## WESTMEAD CATHOLIC COMMUNITY EDUCATION CAMPUS ATTACHMENT E - RESPONSE TO OPEN SPACE CLARIFICATIONS

**Note:** We have previously quoted the open space within the building (from Levels 1 – 5) as being ‘over’ 7,800sqm. When combined with the previously quoted ground level open space area of 6,070sqm, there was a total provision of 13,870sqm of open space, or 8.26sqm per student. To be conservative, this was rounded down to 8.2sqm per student.

OPEN SPACE - LEVEL 04 & LEVEL 05

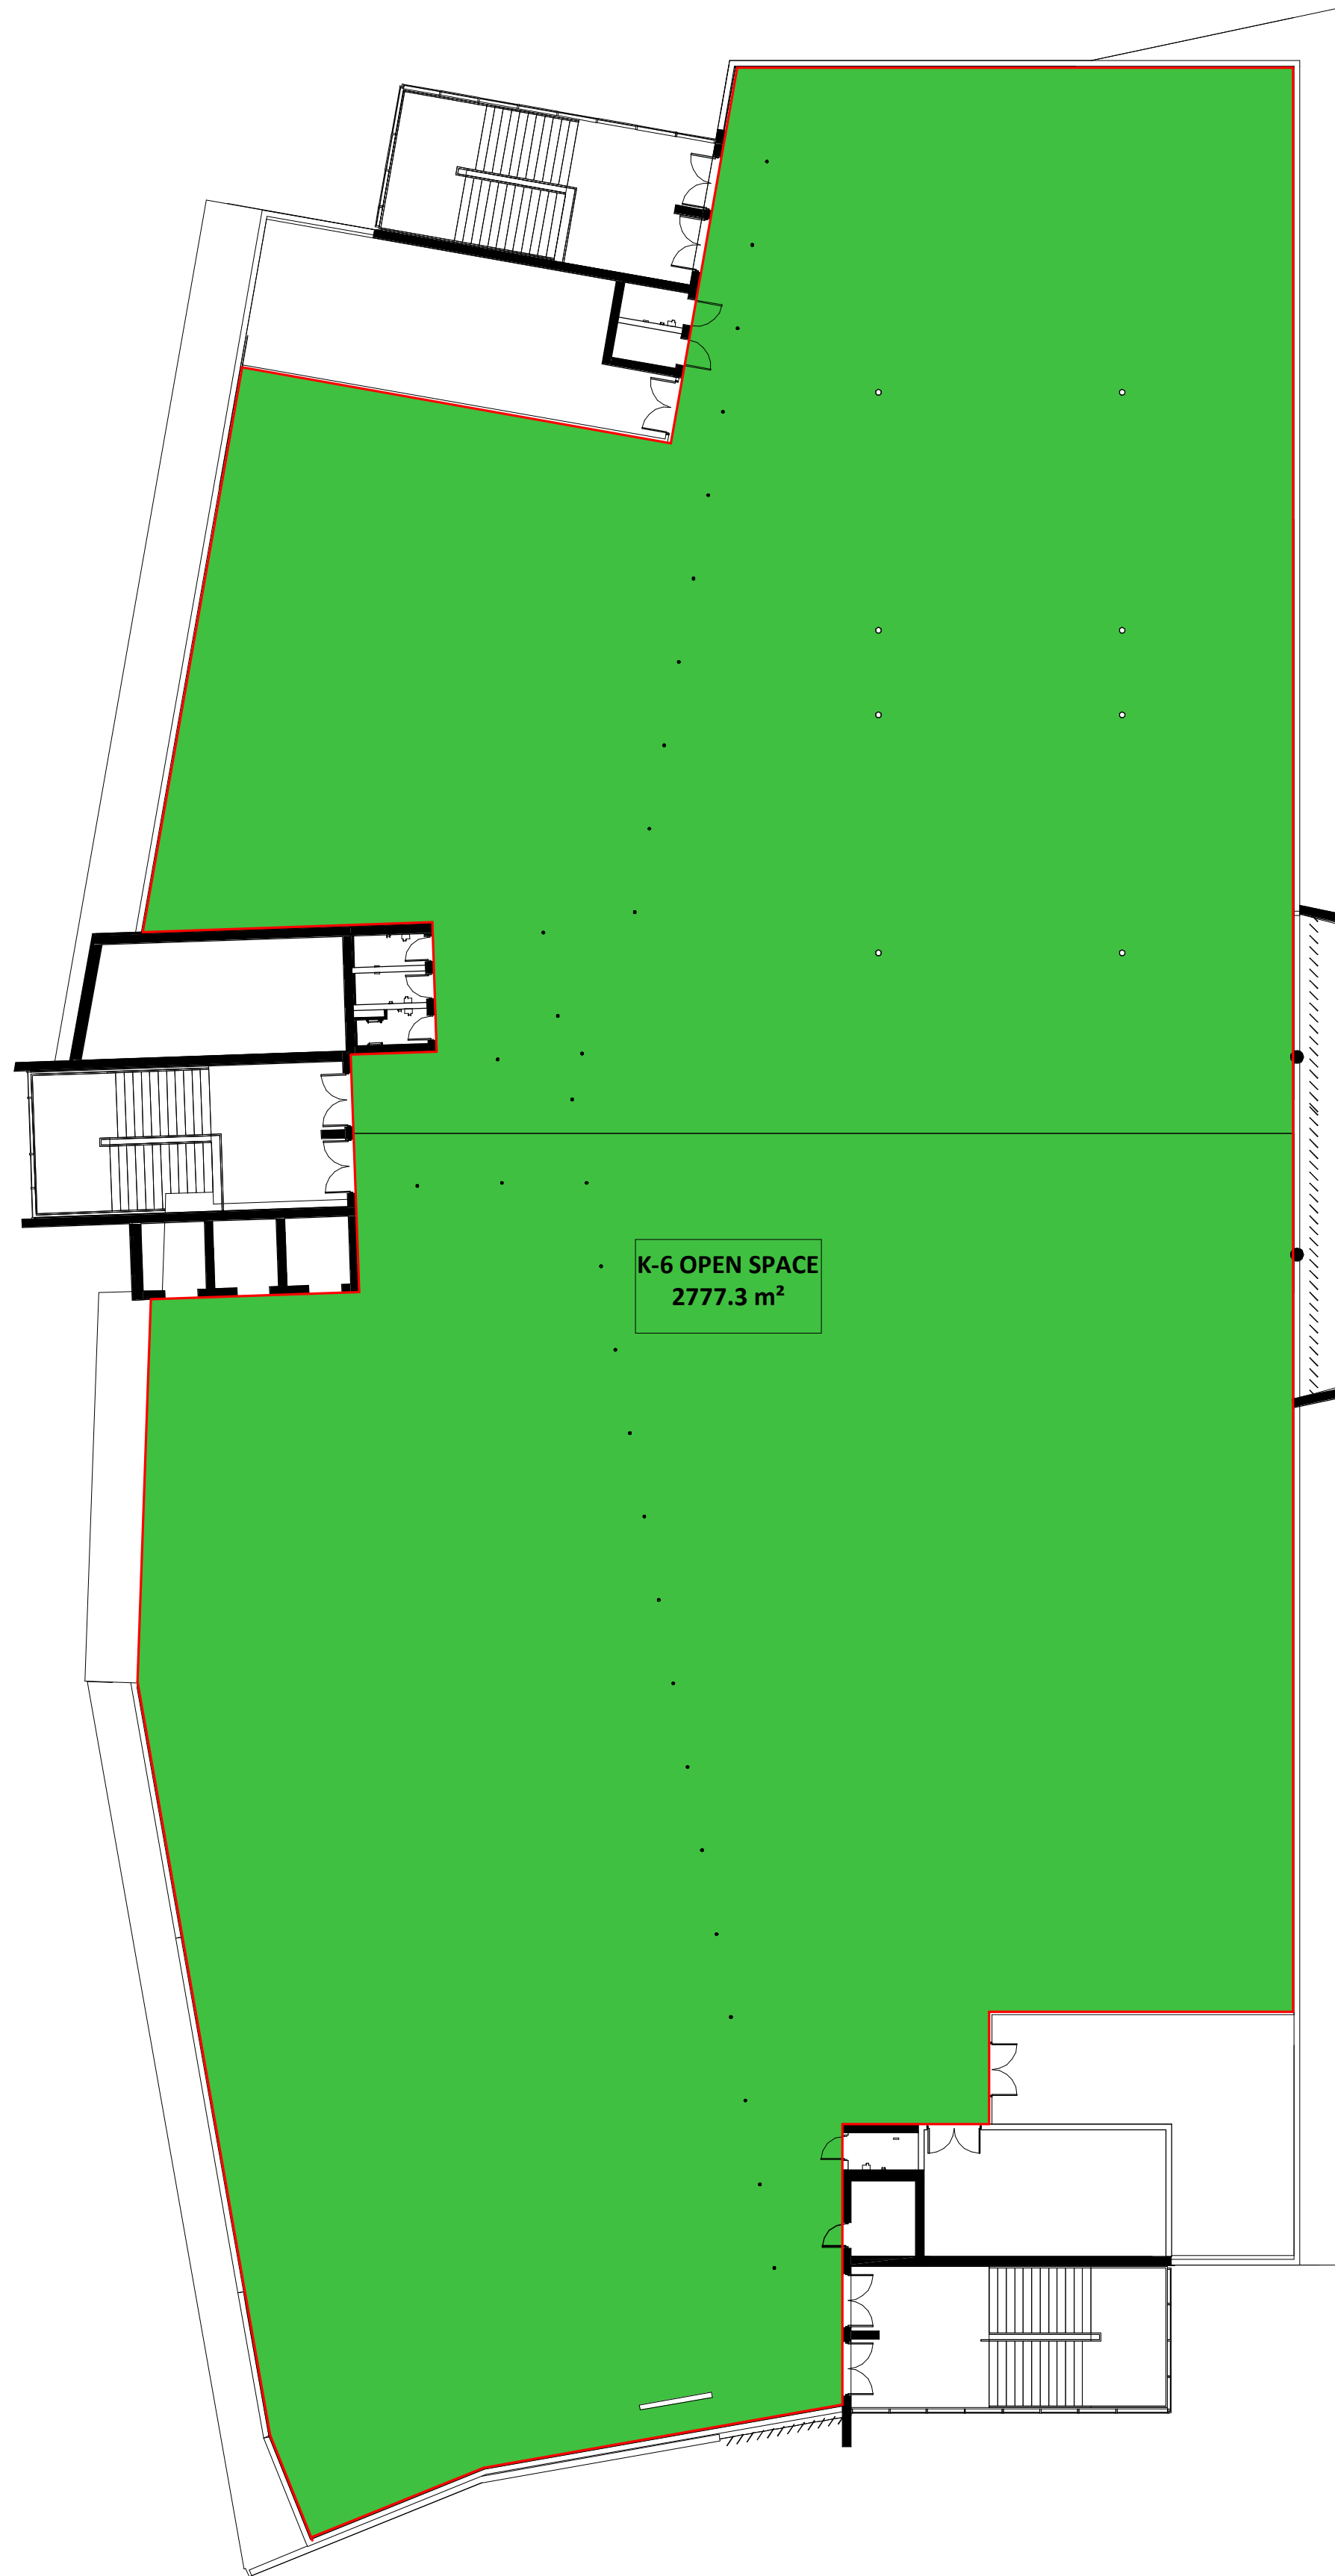
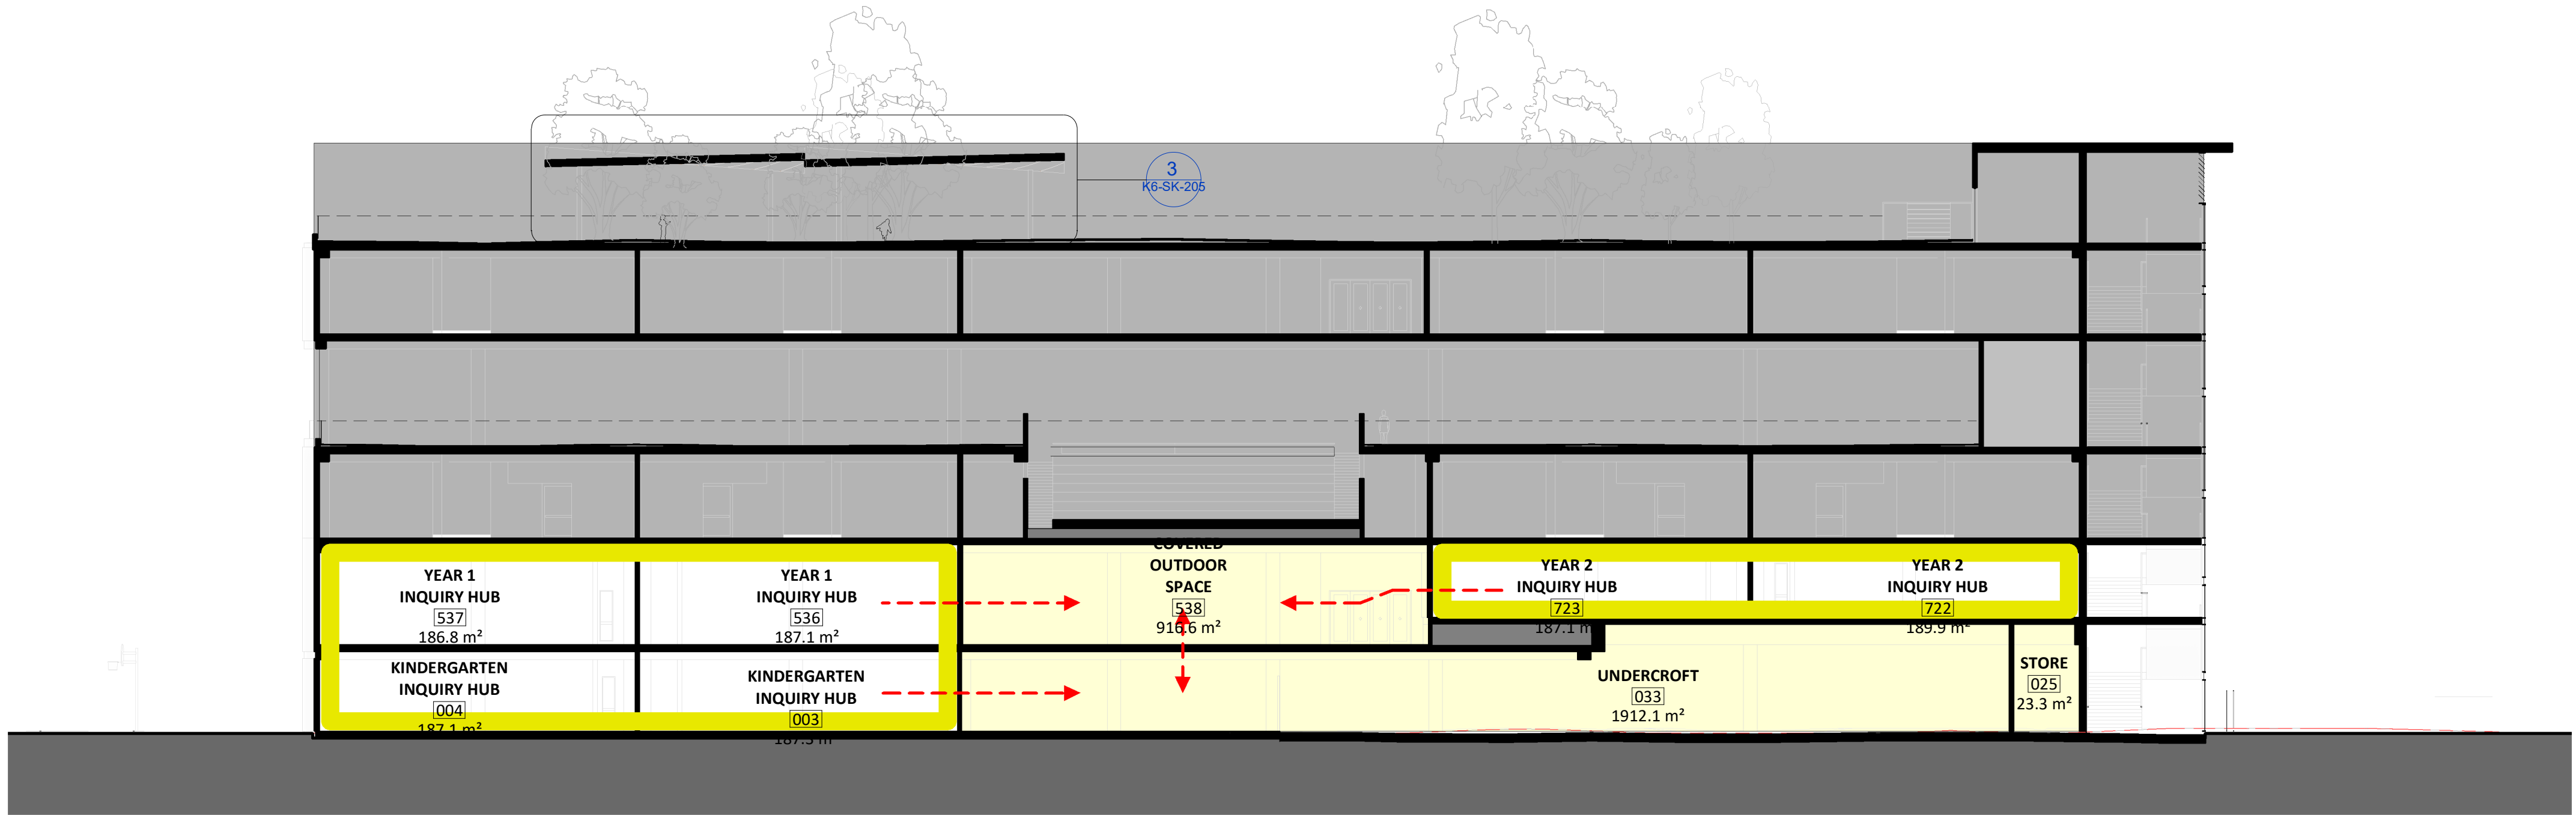
b	The Response to Submissions (RtS) advises that the outdoor play spaces would be divided between year groups (K-2 at ground and Level 1, Years 3-4 at Levels 4 and 5, and Years 5-6 at Levels 2 and 3). The application also advises that the school building has been designed to minimise vertical movement to one level up or down, where possible. However, the plans note that each outdoor play space would be accessible for all K-6 students. Please clarify the quantity of open space to be provided per student for each year	<p>It is noted that primary students of all year groups will have access to all play areas at the ground level and upper levels of the building, with access to ultimately be determined by operational factors such as supervision and suitability, which will be determined by the teachers when the school becomes operational.</p> <p>However, as described in DPIE's comment, dedicated open space areas have been identified for different year groups. These open space areas are provided adjacent classrooms with a vertical</p>

Item No	Clarification	Response
	<p>group (e.g. Years 5 and 6 students at Levels 2 and 3). Please also quantify the amount of unencumbered ground level open space access to be provided for each year group. This information should be provided in a table/schedule format.</p>	<p>connection one level up or one level down to significant play space so as to minimise circulation time and maximise recreation opportunities. Whilst all students will have access to ground level open space, as noted in DPIE's comments, the ground level is identified to be used primarily by Kindy – Year 2. For developmental reasons, it is not uncommon for younger students to have separate play areas to older students.</p> <p>Whilst there will be no dedicated area of ground level open space for other year groups, students will not be precluded from travelling between different levels of the building to access open space (from ground to upper levels) when it is appropriate to do so, such as during free play. This will be managed by CEDP via an operational guideline, which will ensure that all students have access to open space that is appropriate for their needs, both in terms of quantity and design.</p> <p>A schedule of open space provision by year group is <b>attached</b>. It shows that some year groups notionally have more open space than other cohorts, as follows:</p> <ul style="list-style-type: none"> <li>Kindy, Year 1 and Year 2 = 9.31sqm (Ground and Level 1)</li> <li>Years 3 and 4 = 7.43sqm (Levels 4 and 5)</li> <li>Years 5 and 6 = 7.42sqm (Levels 2 and 3)</li> </ul> <p>This breakdown shows that the variations between cohorts are minor, and the year groups with slightly less open space still receive a sufficient provision of purpose-designed play space. Further, when considered across the broader primary school area, students will each have access to 8.2sqm of dedicated primary school open space.</p> <p>Finally, we note that these figures exceed the current open space provision for Mother Teresa students (7sqm/student) and would significantly exceed the provision at Sacred Heart Primary School, once the play space is no longer available (2.3sqm/student). This demonstrates the urgent need to relocate students from the existing Sacred Heart Primary School site.</p>

Year Group	No. Students	Open Space	Open Space Per Student/m2
Ground	Kindy	240		
Level 1	Yr 1	240	6,704	9.31
	Yr 2	240		
Level 2	Yr 5	240		
	Yr 6	240	3,560	7.42
Level 3				
Level 4	Yr 3	240		
	Yr 4	240	3,564	7.43
Level 5				
<b>Total</b>		<b>1,680</b>	<b>13,828</b>	<b>8.23</b>
